Cover letter and revised permit drawings for changes to impacts at permit site 55

Subject: **Modification Request for Section 404 Individual Permit, Section 401 Water Quality Certification and Neuse Riparian Buffer Authorization** for Interstate 40 Widening and Improvements from I-440/US 64 (Exit 301) to just north of SR 1525 (Cornwallis Road), including improvements to NC 42 and SR 1010 (Cleveland Road) in Wake and Johnston Counties, Federal Aid Project No. IMNHF-040-4(139)301; TIP Numbers I-5111 and I-4739, Division 5. Debit \$570 from WBS Element 42346.3.1.

Attached are the following revised permit drawings depicting the affected area, all of which have a revision date of June 1, 2022:

PROJECT REFERENCE NO.	SHEET NO.
1-5111/1-4739	49
R/W SHEET NO.	
ROADWAY DESIGN ENGINEER	HYDRAULICS ENGINEER
INCOMPLETE PLANS DO NOT USE FOR R/W ACQUISITION	
DOCUMENT NOT CONSIDERED FINAL UNLESS ALL SIGNATURES COMPLETED

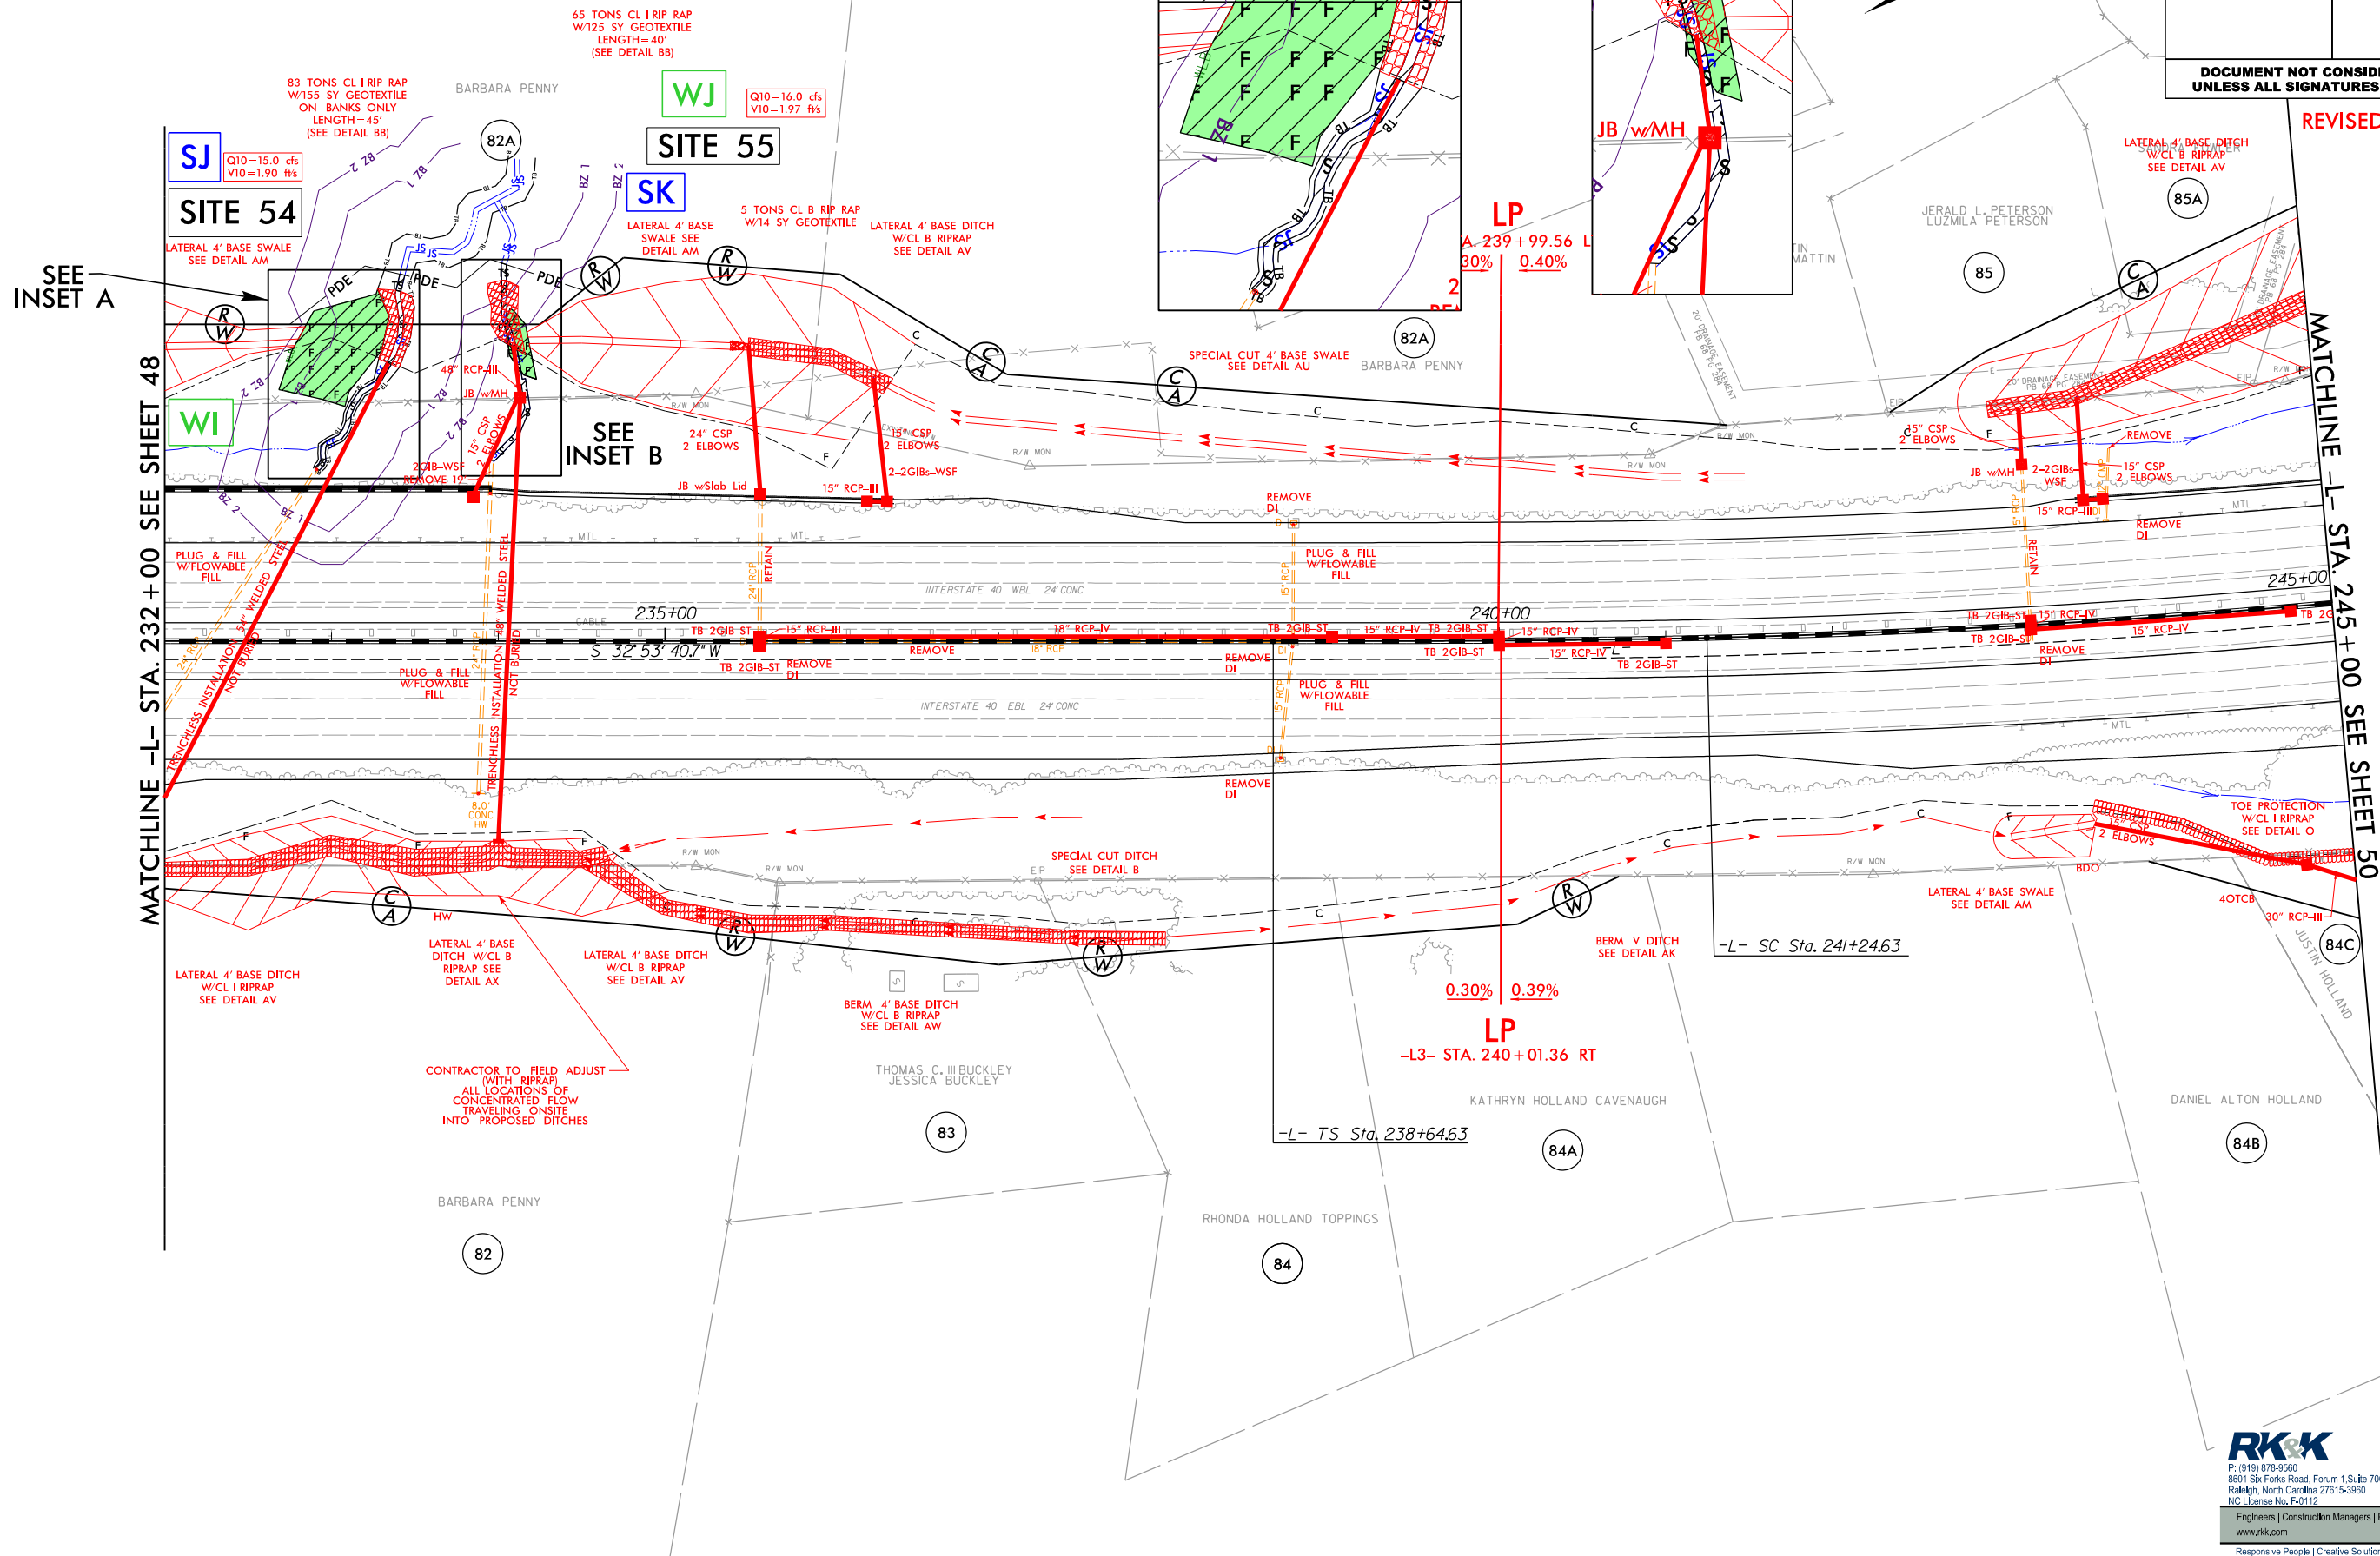
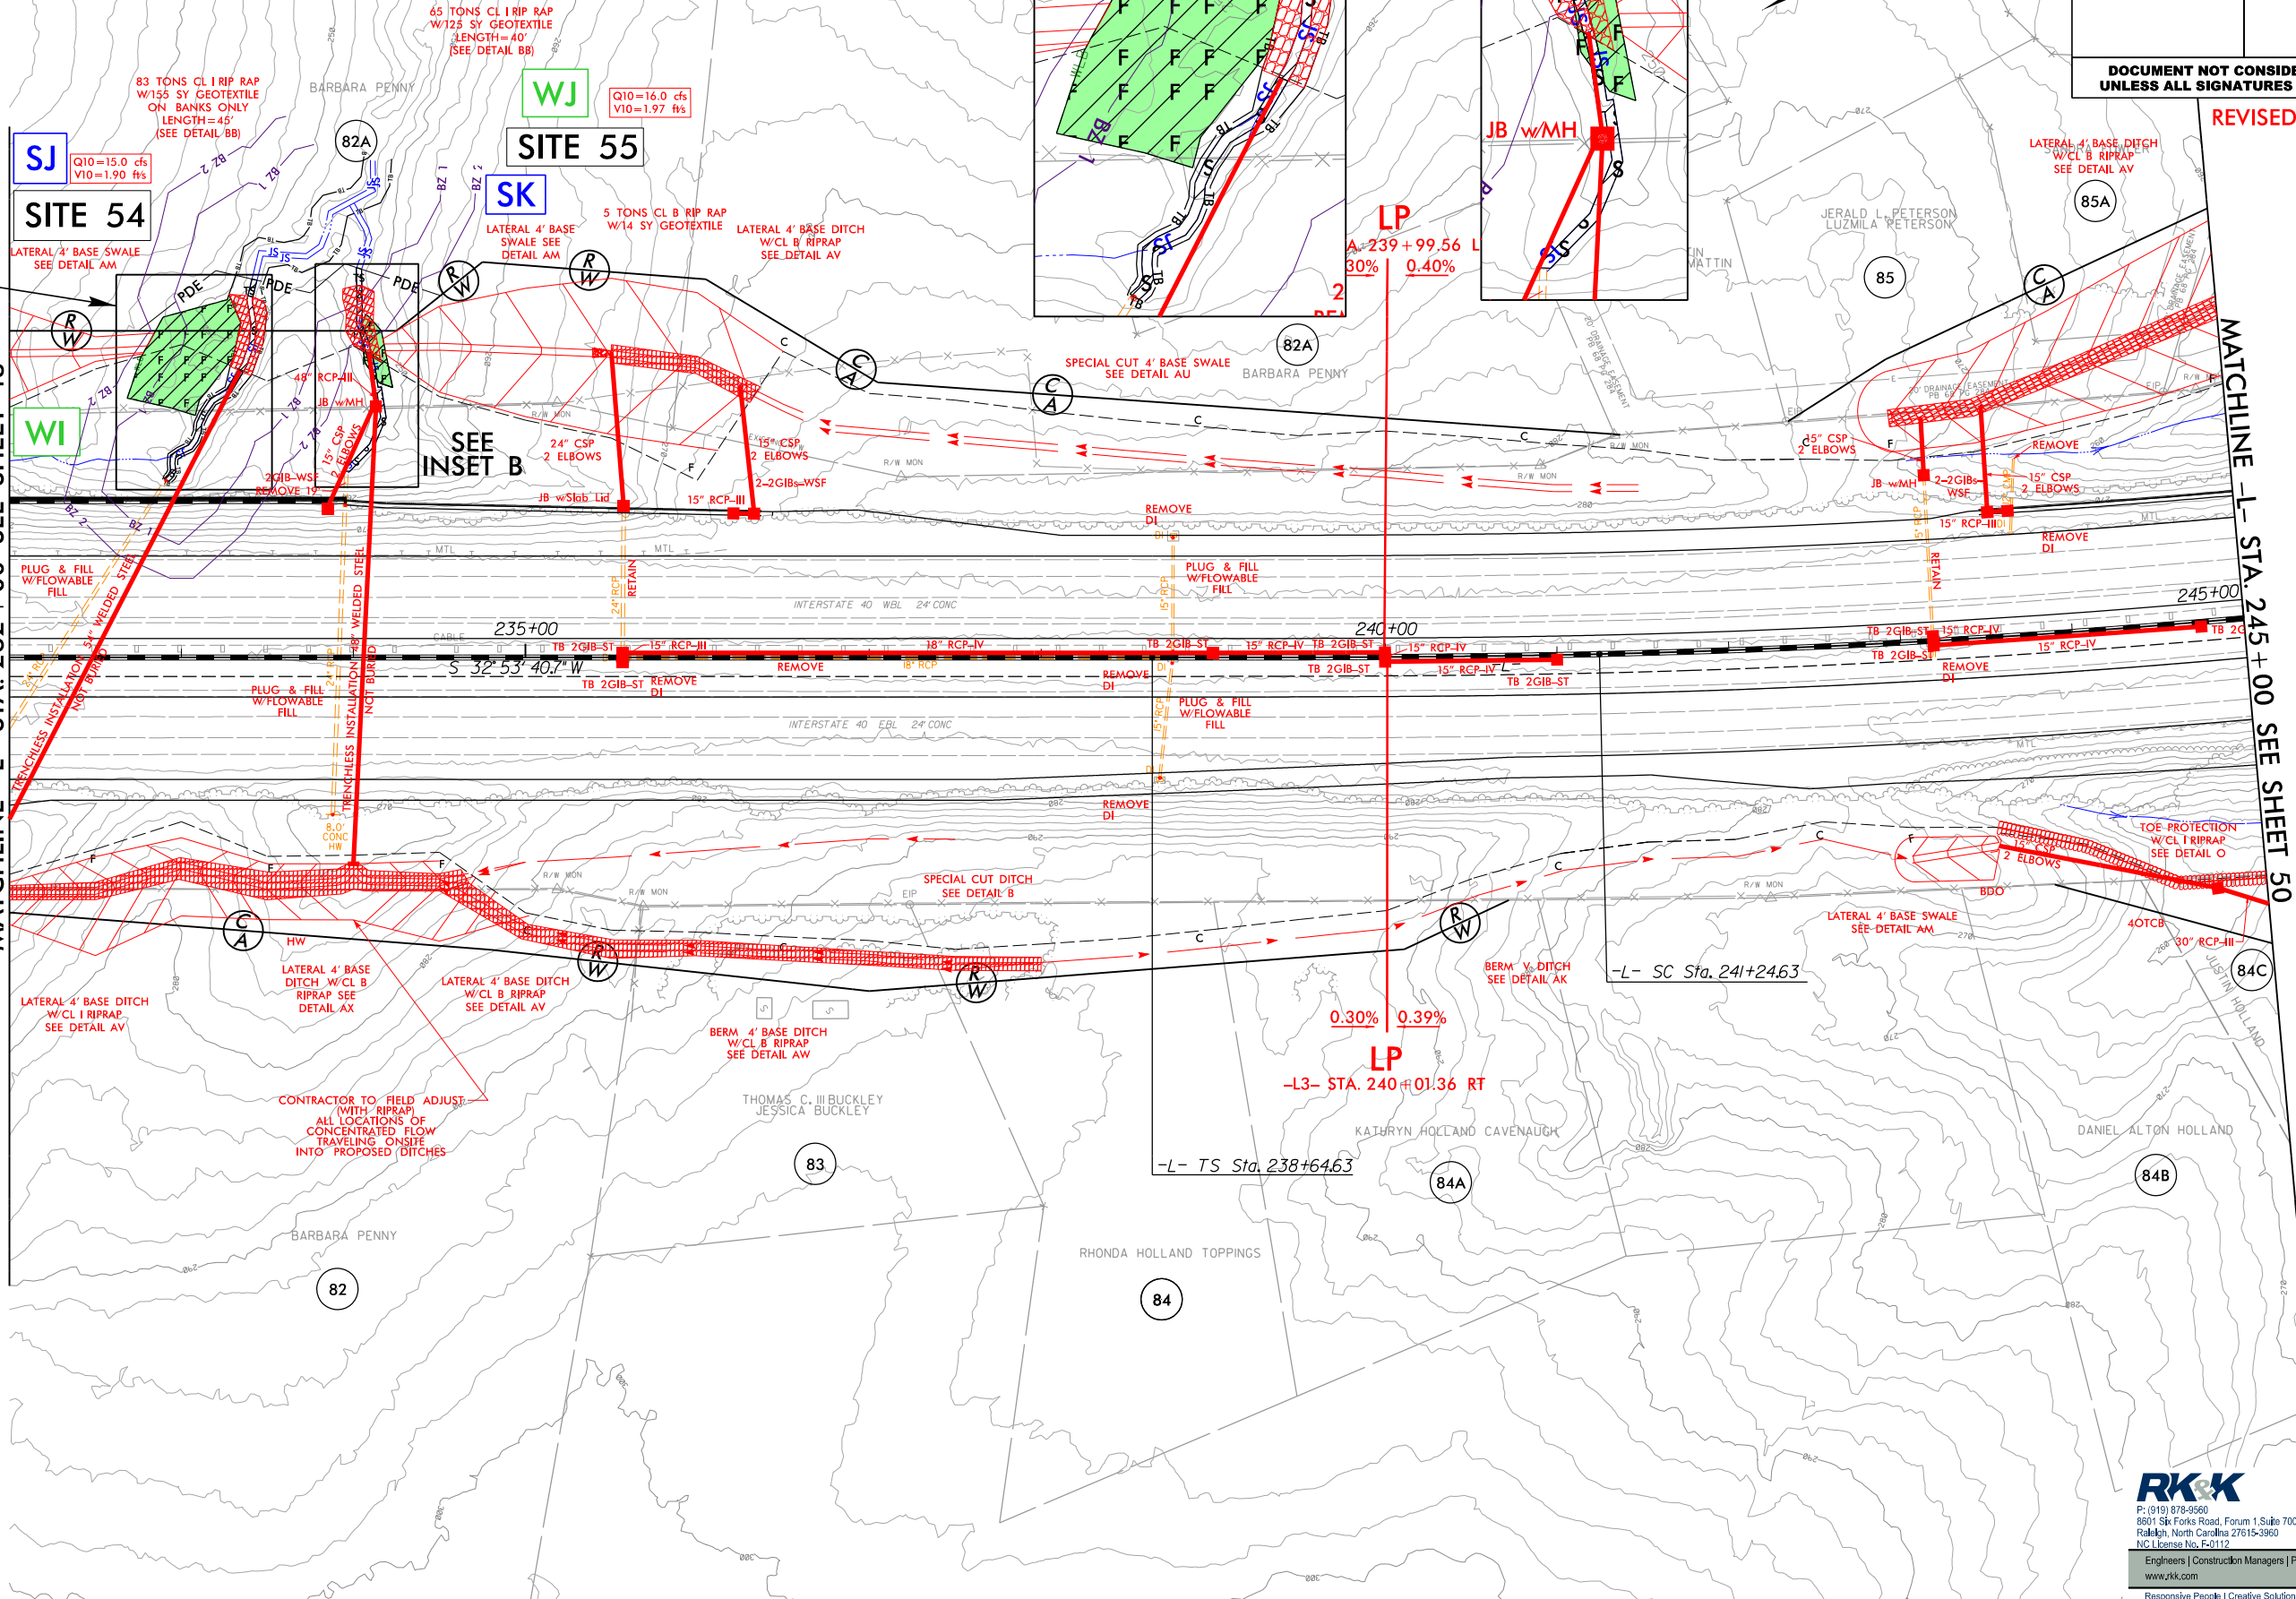
Site 55: Due to repeating erosion events and the general instability of the channel below the outlet of Site 55, the Design Build Team proposes rip rap be added to the flow line to match the length of the previously permitted bank stabilization. This will result in the following changes:

- 40 linear feet decrease in bank stabilization impacts
- 40 linear feet increase in permanent stream impacts
- No changes in buffer impacts
